DOC23/83483

15 February 2023

**Sydney Metro West – The Bays to Sydney CBD
Modification 1 – to remove limits on 24-hour tunnelling (SSI 19238057 Mod 1)
EPA advice on Modification Request**

The EPA has reviewed the document *Modification Request (Mod 1)*, dated 1 February 2023, prepared by Sydney Metro (Modification report). The Modification report also discusses a proposal to relocate a train crossover passage from east of The Bays Station to west of Pyrmont Station. This has formed part of a separate consistency review but the outcomes of a Detailed Noise and Vibration Impact Statement (DNVIS) for the crossover passage are discussed in the report.

**Figure 2 Typical cavern excavation passes**

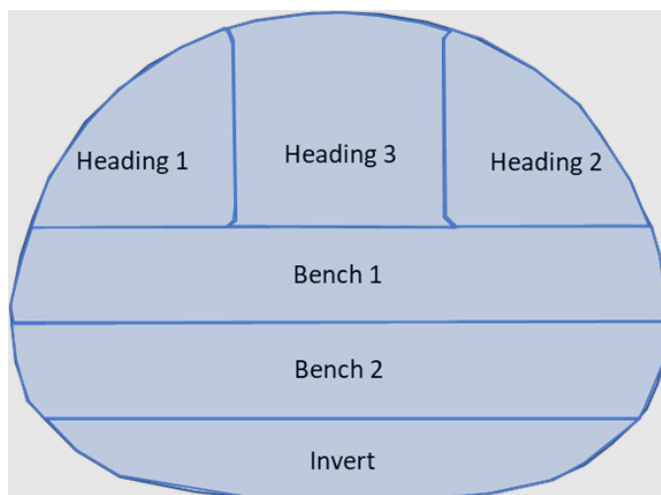
Regarding the interface between the Pyrmont Station cavern and crossover passage excavation works, the Modification report states: *“Some receivers in proximity to the Pyrmont crossover cavern adjacent to the station cavern may experience longer duration as a result of additional non-TBM tunnelling, however the impacts are similarly expected to remain for around six to 12 weeks.”*

The EPA requests more information is provided to explain what is meant by this statement, to identify impacts to receivers that may fall into the Venn diagram of the Pyrmont Station and Crossover work areas, and to outline the reasonable and feasible mitigation measures that would be applied to reduce construction noise impacts below NMLs.

**Figure 3** Indicative Ground-borne Noise Levels from TBMs (top) and Roadheaders (bottom)

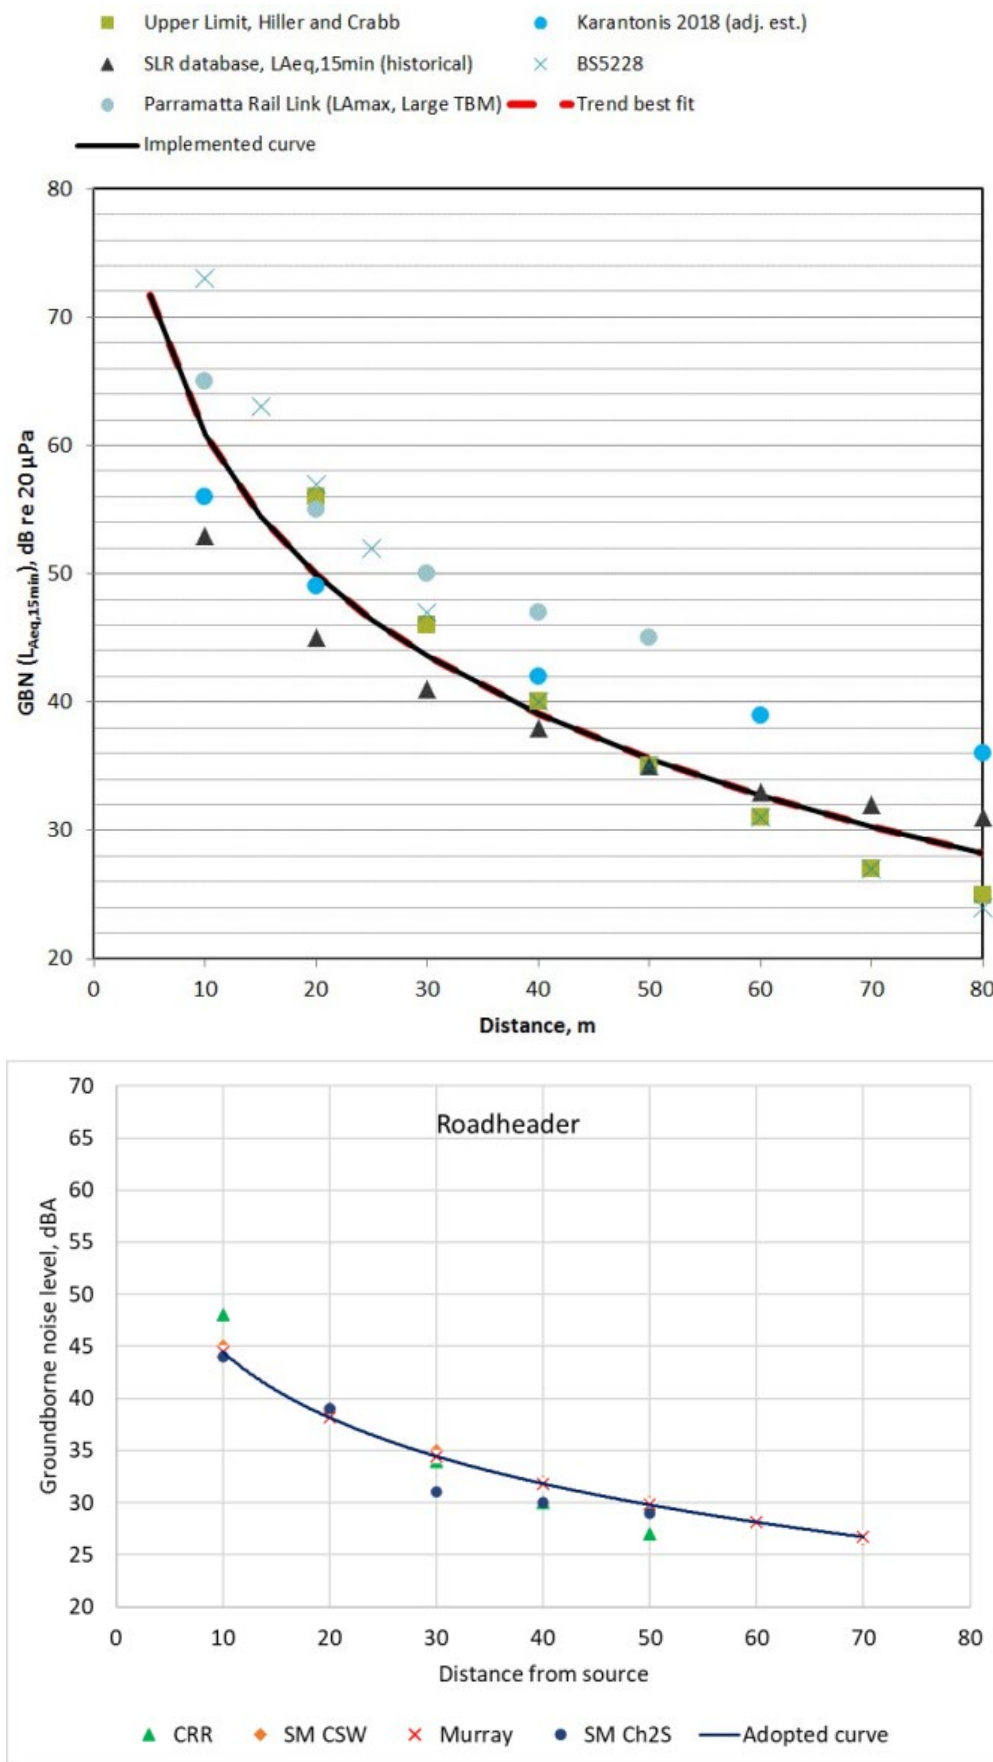
Regarding the station cavern excavations, the Modification report states “... *the proposed depth of Pymont Station cavern ranges from around 36-39 metres. Applying the ground-borne noise level graph in Figure 3 ... noise levels would be expected to comply with noise management levels in most cases with some potential for marginal exceedances in the 1-5dB range.*” Figure 3 illustrates the sliding scale of ground borne noise levels in relation to distance from the receiver and shows that “*the residential night-time noise management level of 35 dBA would only be exceeded when works are within a 30 metre slant distance from receivers.*”

This additional information regarding tunnel depth at Pymont, coupled with indicative road header noise levels in Figure 3, provides the EPA with increased confidence that ground-borne noise impacts at Pymont may be kept below NMLs. However, the Modification report states that exceedances could be in the 1-5 dB range (6-10 dB above background). The report does not identify how frequently or for how long these “marginal exceedances” would occur.

The EPA requests the Response to Submissions provide details on the frequency and duration of any exceedances of NMLs at Pymont Station, and the reasonable and feasible mitigation measures that would be applied to reduce these impacts.
